Consultation Response from Mark Berry KC, Highways Development Management		
2021/91932 Former North Bierley Waste Water Treatment Works, Oakenshaw, BD12 7ET		
Reserved matters application pursuant to outline permission 2016/92298 for re-development of former waste water treatment works following demolition of existing structures to provide employment uses (use classes B1(c), B2 and B8) relating to Phase 4 - the construction of 2 x industrial warehouse units with ancillary office accommodation (approximately 6021m2 and 4046m2) with parking and landscaping, including the discharge of Condition 6 (Bio-diversity Enhancement Management Plan), Condition 17 (Site Investigations), Condition 18 (Tree Survey), Condition 19 (Public Rights of Way), Condition 29 (Noise Attenuation) and Condition 31 (Electric Vehicle Charging Points).		
Date Responded:11-10-2021	Responding Officer: Mark Berry	Responding Ref:7-12NE-10

DRAWING NO: 2115 PL 105 (B)

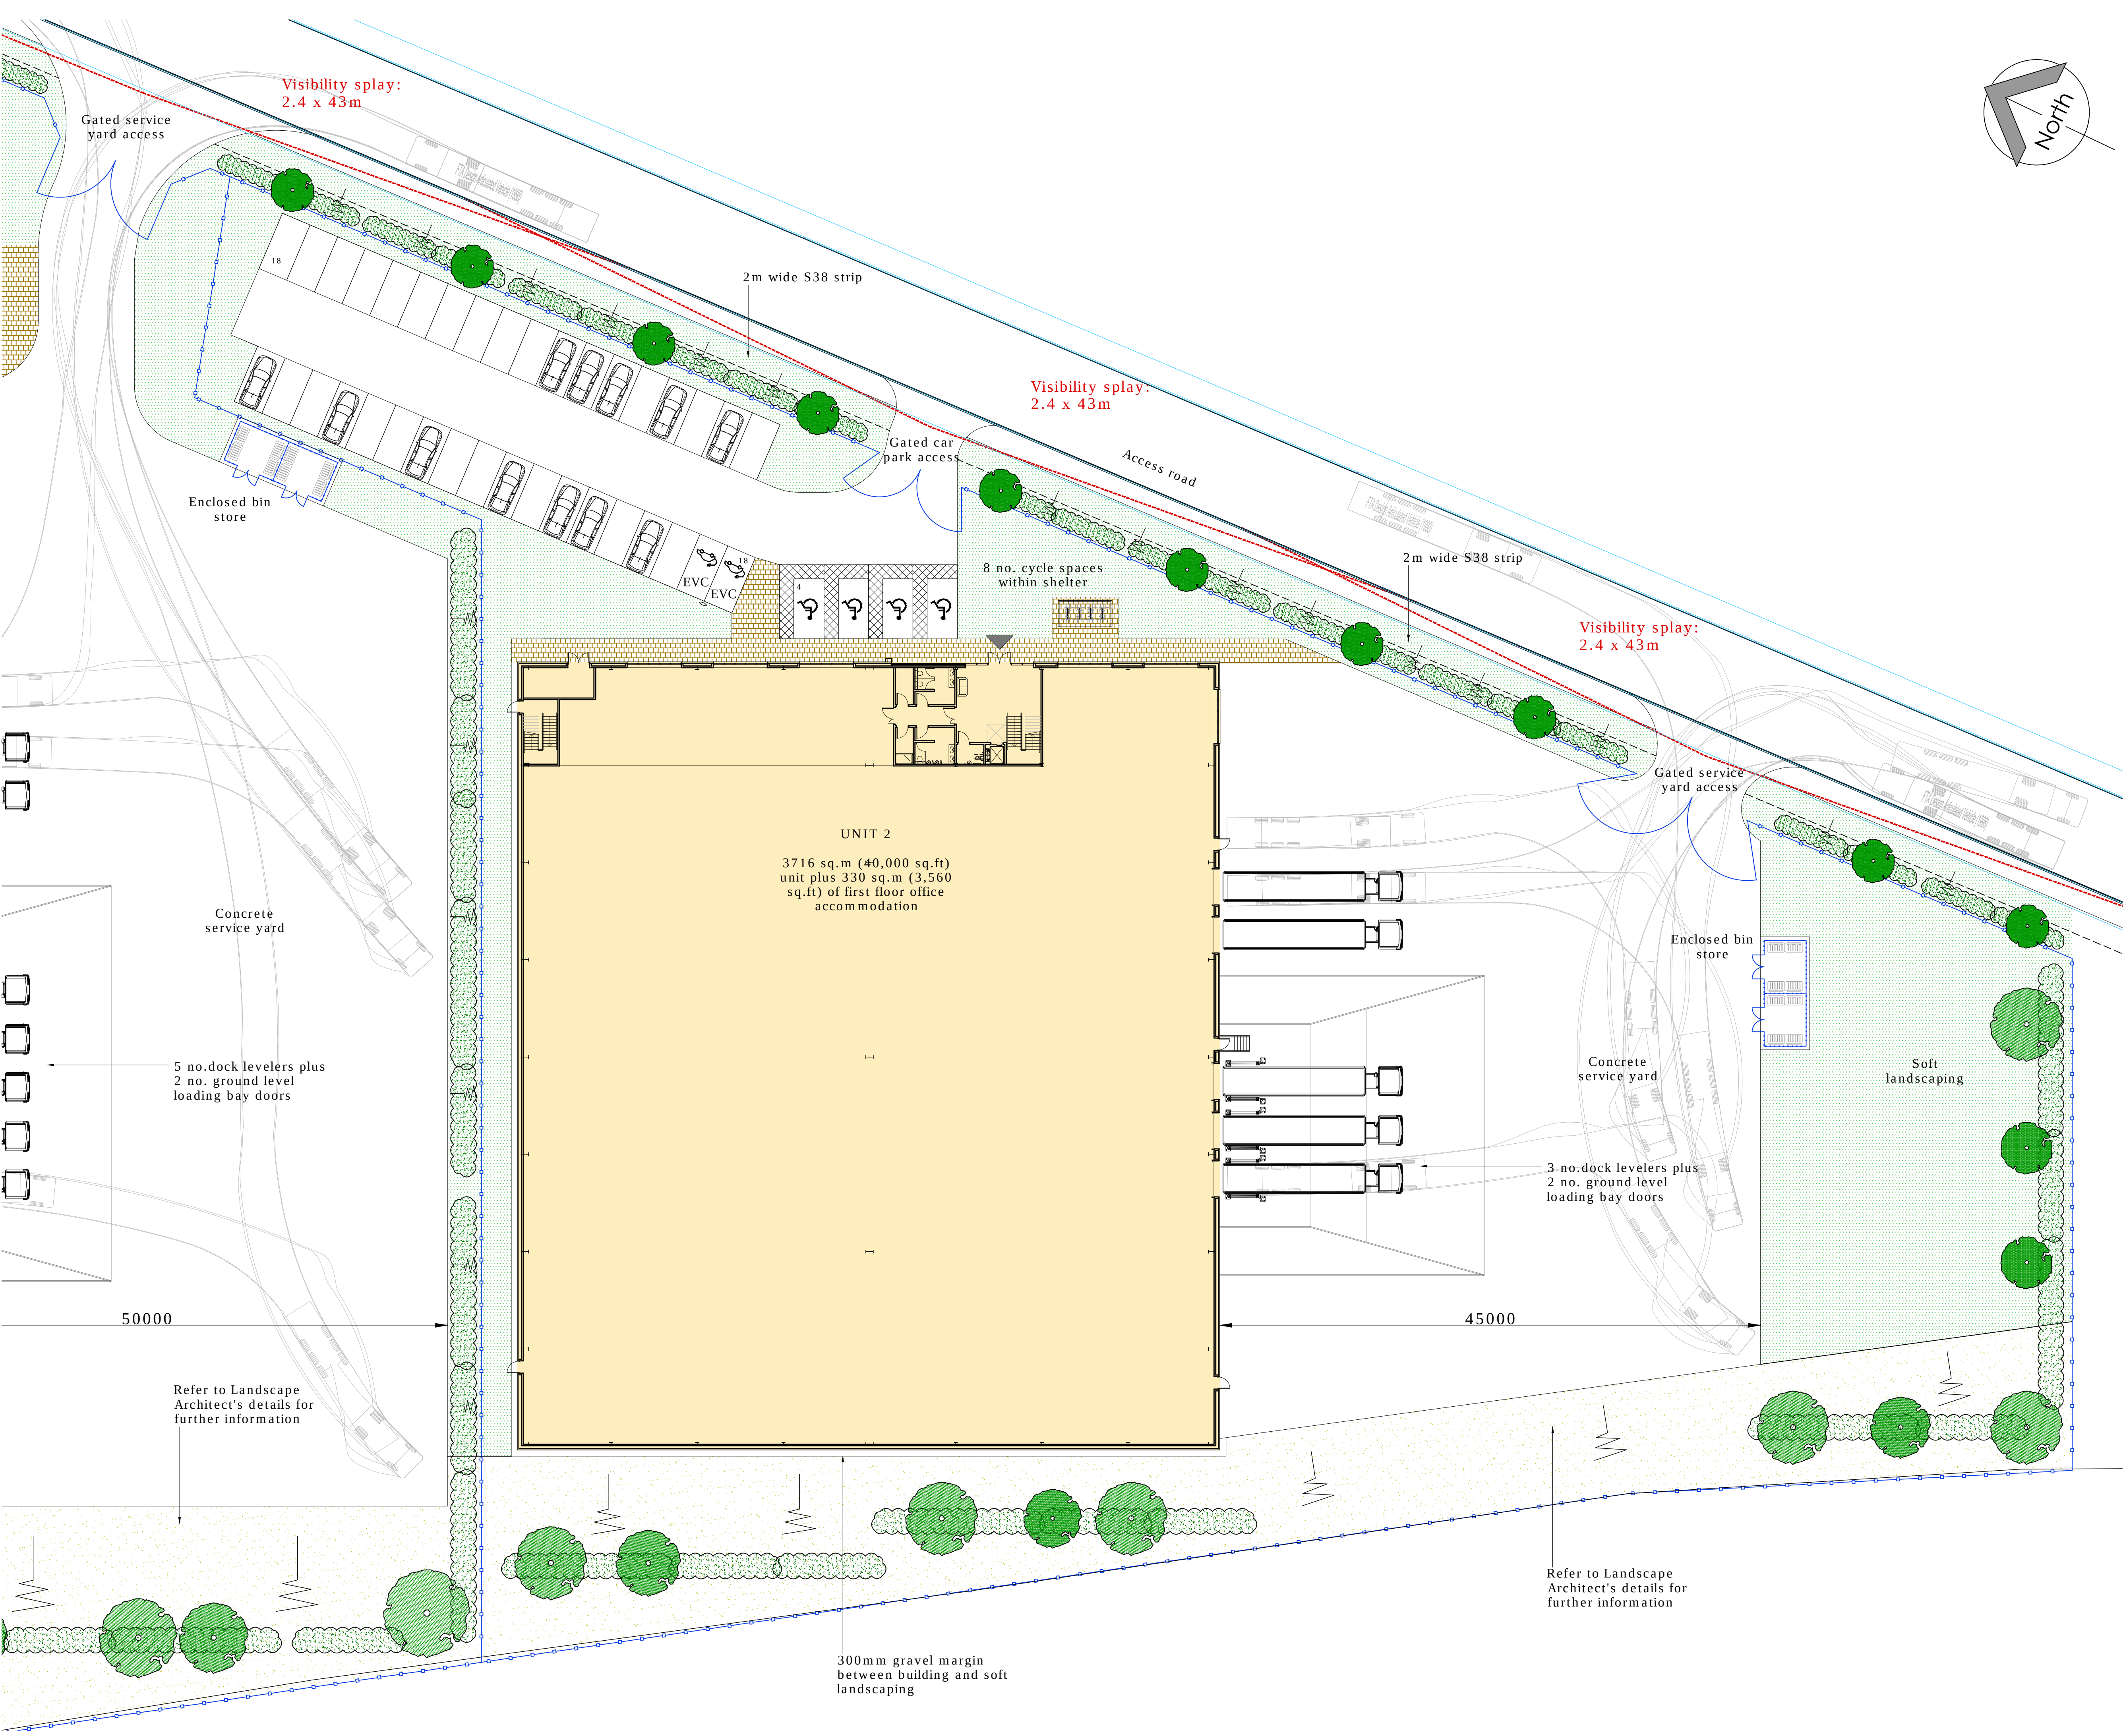
The sight lines from all 4 new accesses onto the phase 1 access road should be shown on the plans.

Swept path analysis to show that a 16.5 metre articulated lorry can enter exit and turn within the service yards to both units should be provided.

Elliss Healey Arctitexture Plan numbers 2115 -PL - 108A showing covered cycle parking, 104B and 105B showing access sight lines.

These proposals are now considered acceptable to Highways Development Management

DRAWING NO: 2115 PL 108 A

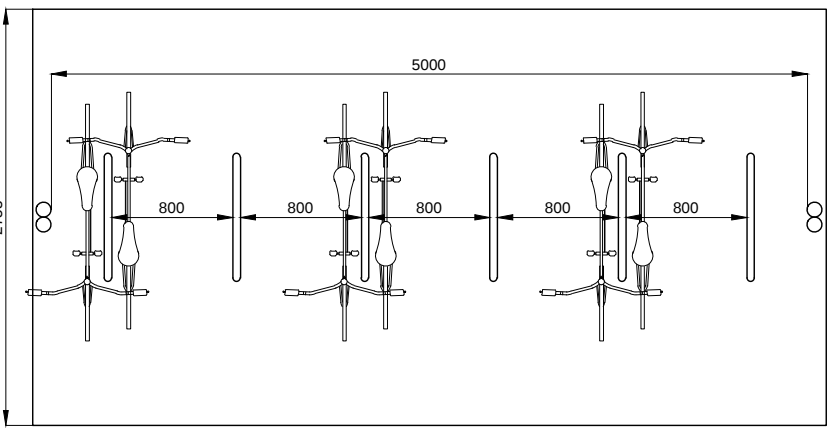
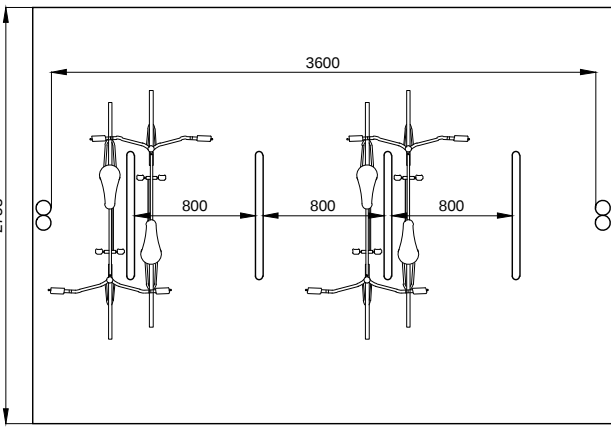
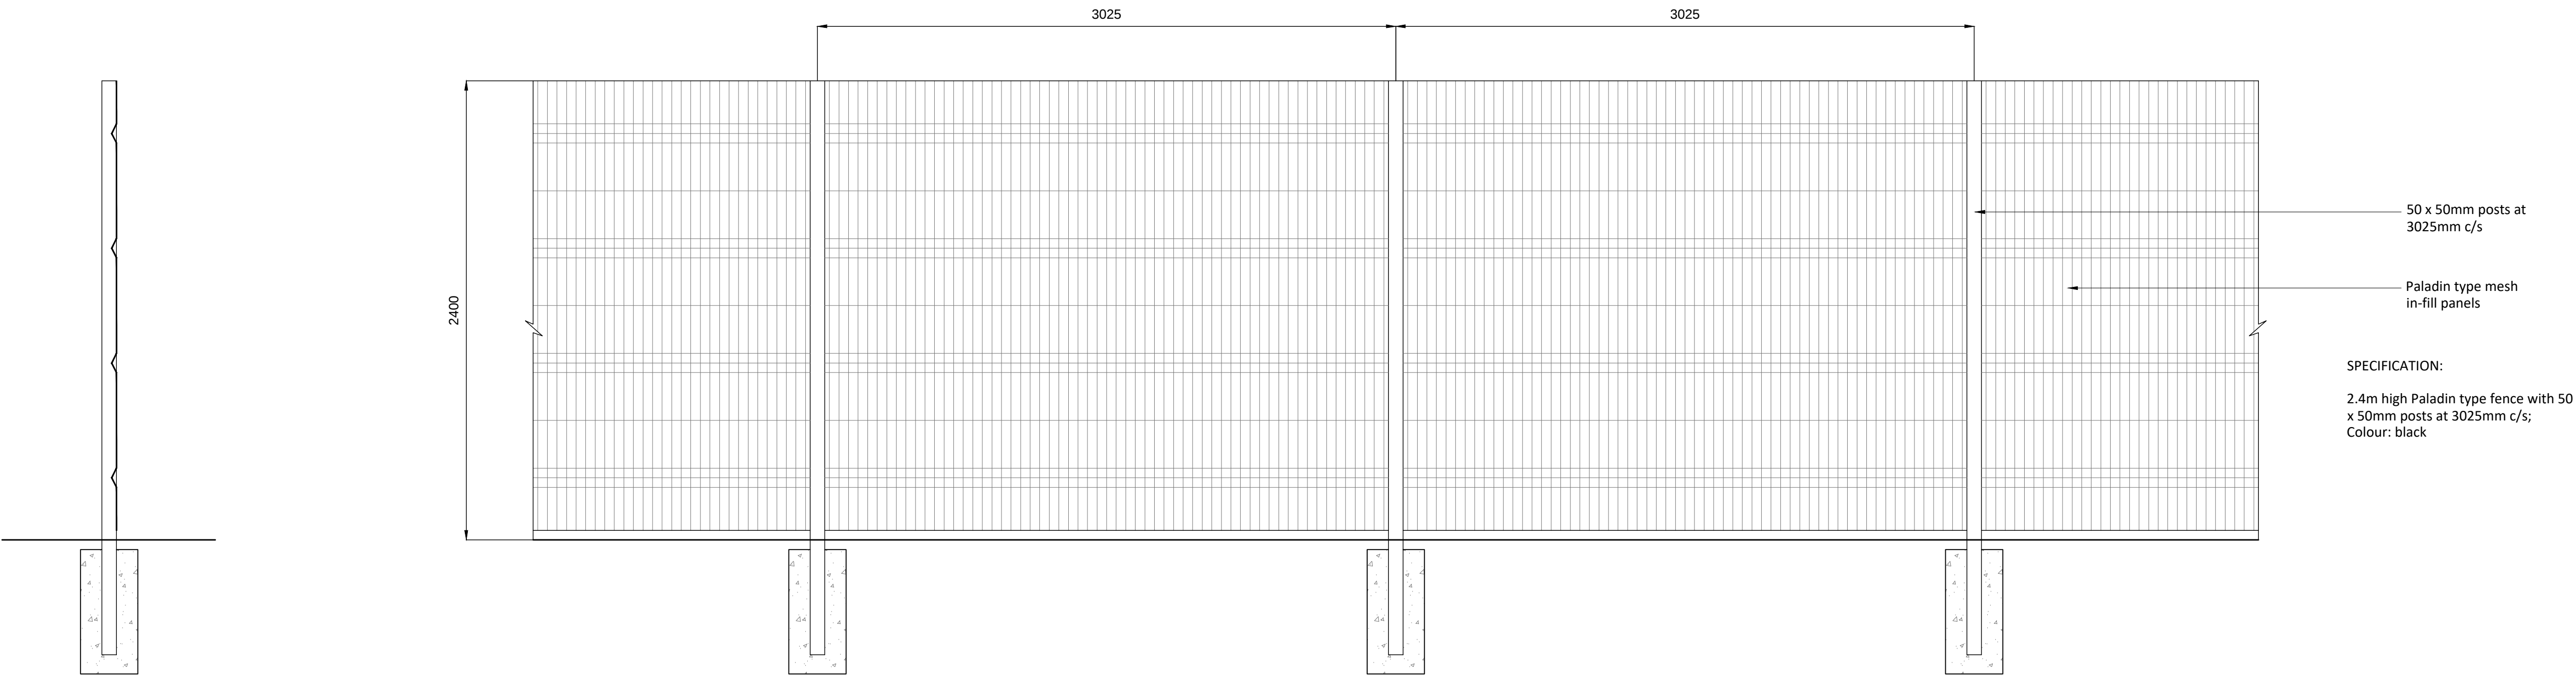
Covered cycle parking should be shown to be provided.
